TAG PEER REVIEW- HODDER BRIDGE, CLITHEROE, 21 JUNE, 2021

James Ellis, Director at Rural Solutions and planning consultant for the owners, invited the Traditional Architecture Group Peer Review Panel to assist in commentary on proposals for a new house at Hodder Bridge, Clitheroe. The Peer review follows pre-application consultation the applicant has undertaken with the local authority.

An application is to be made as an NPPF clause 79e application.

LANDSCAPE MASTERPLAN

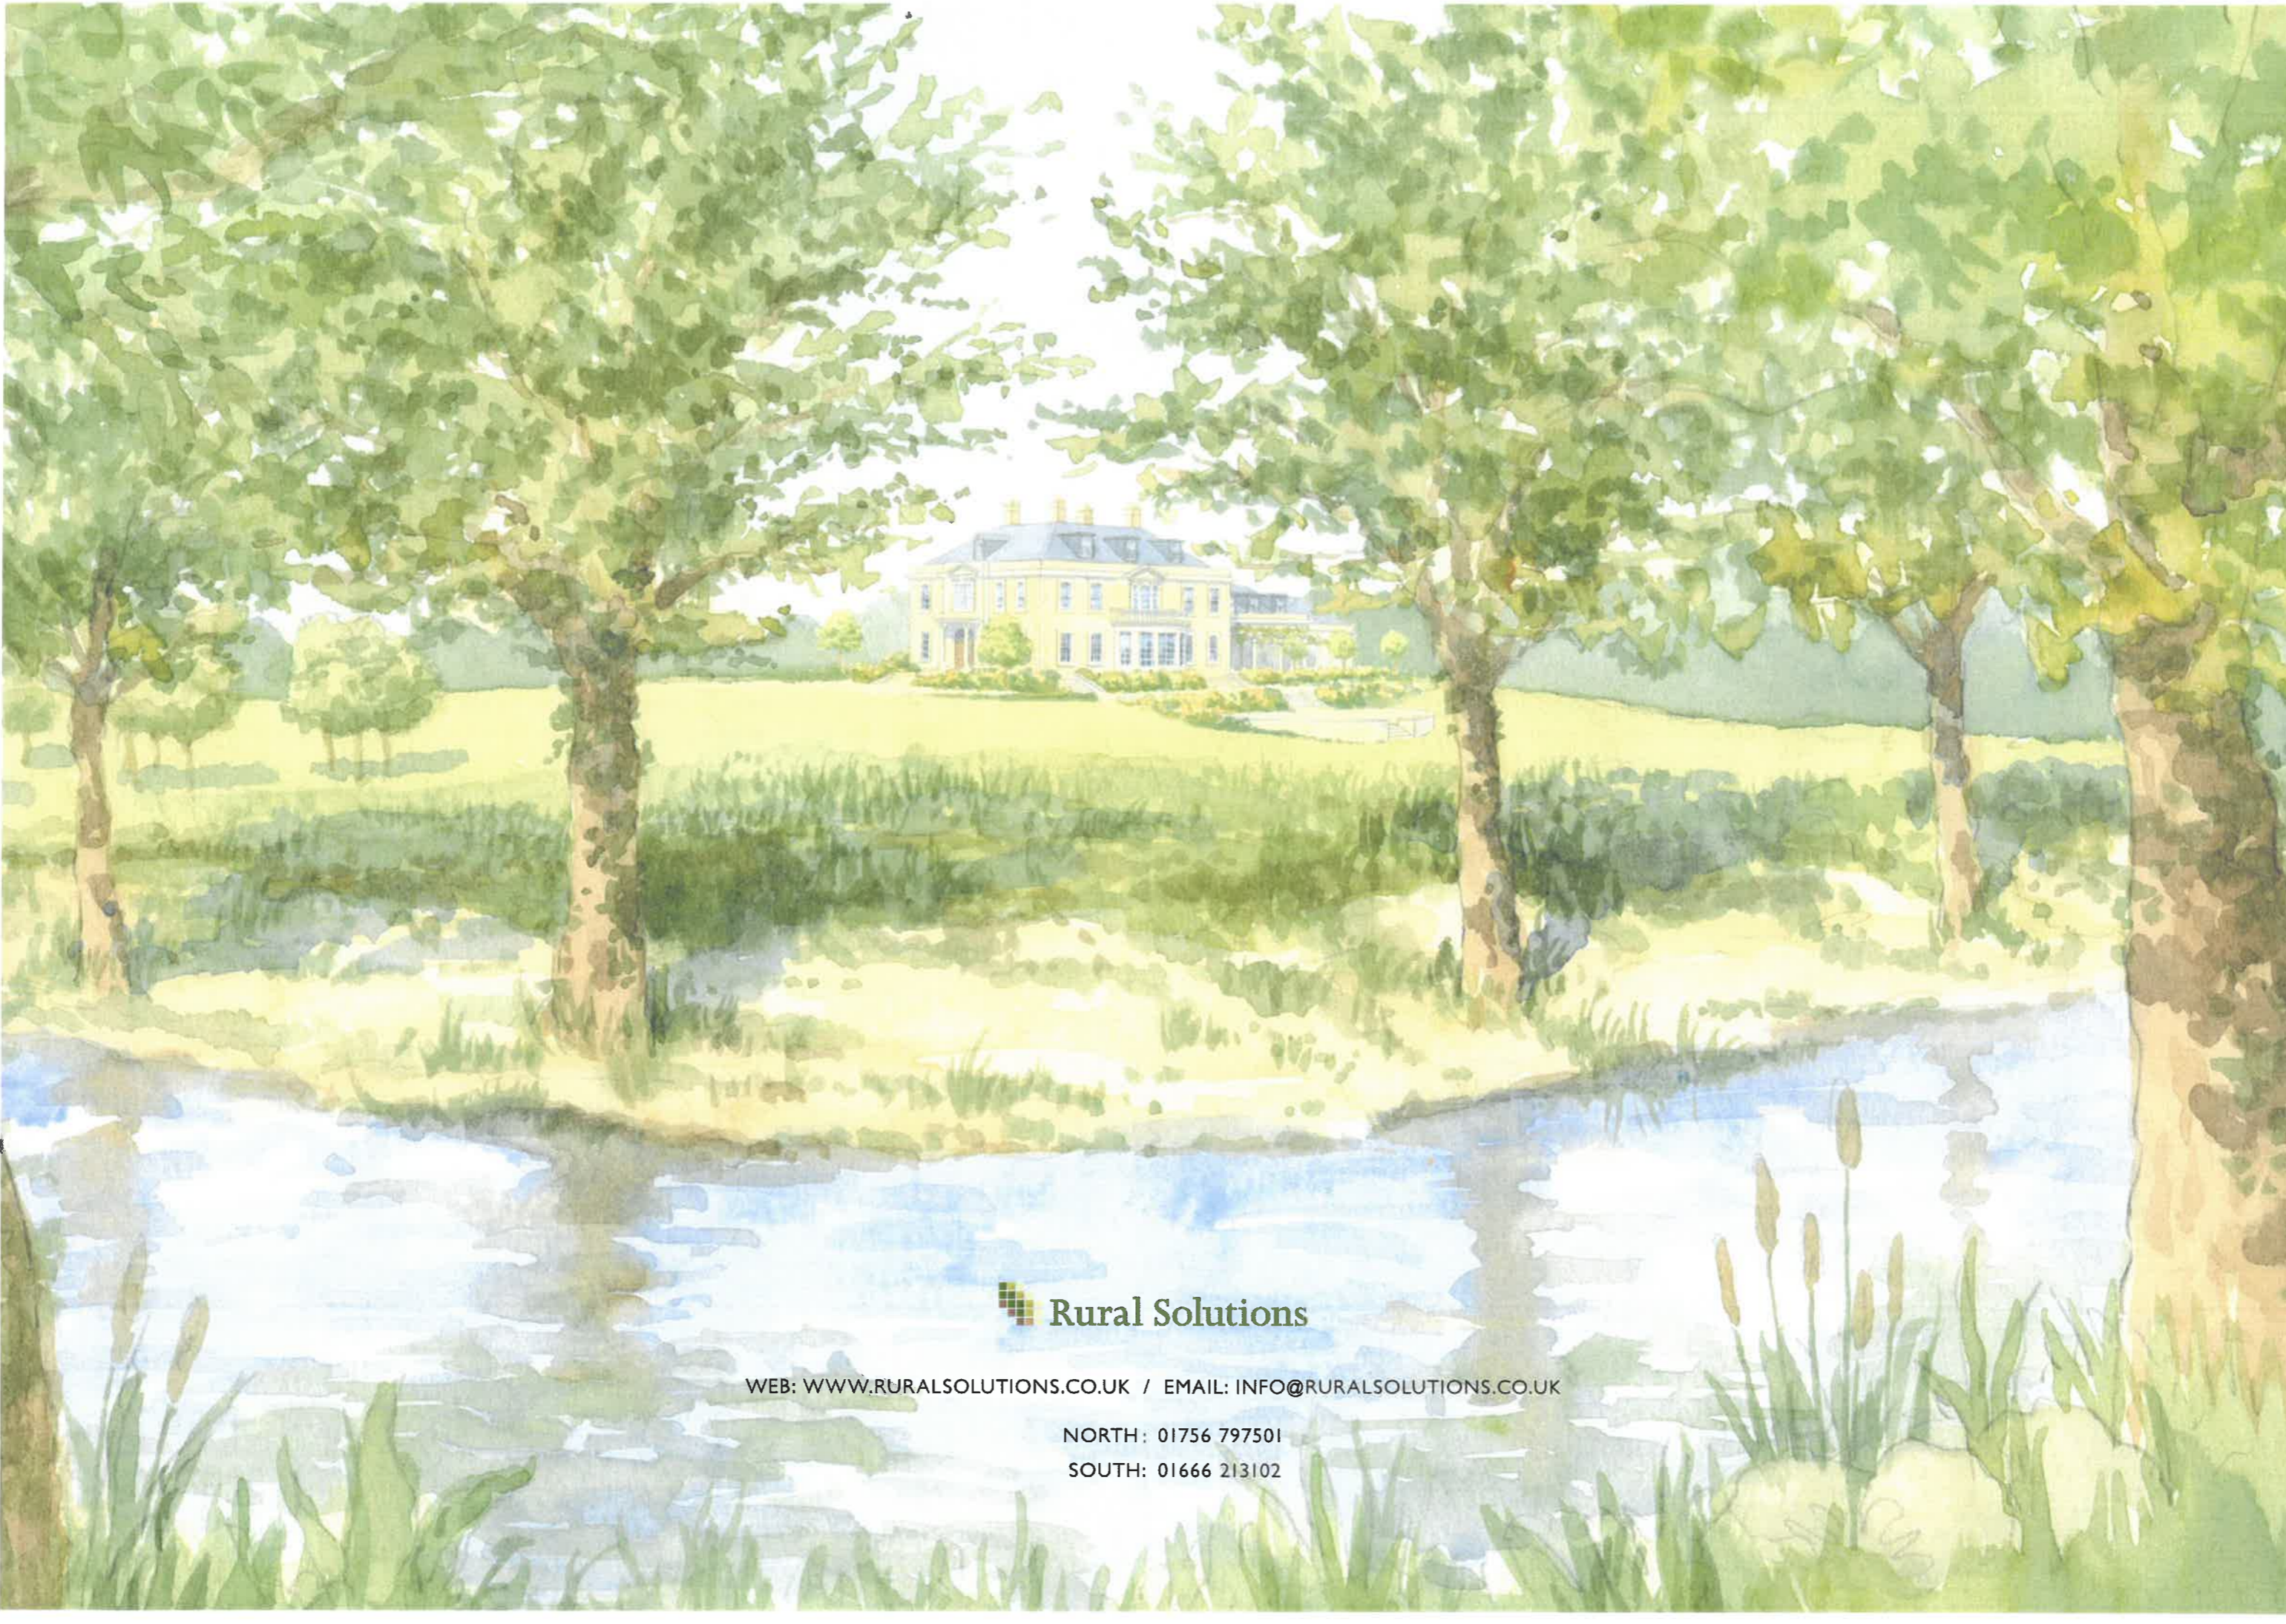
The panel considered an opportunity exists to reconsider the pond location, scale and shape to create a landscape feature with both ecological and visual benefits to reinforce the parkland character without formalising the emerging views of the proposed house.
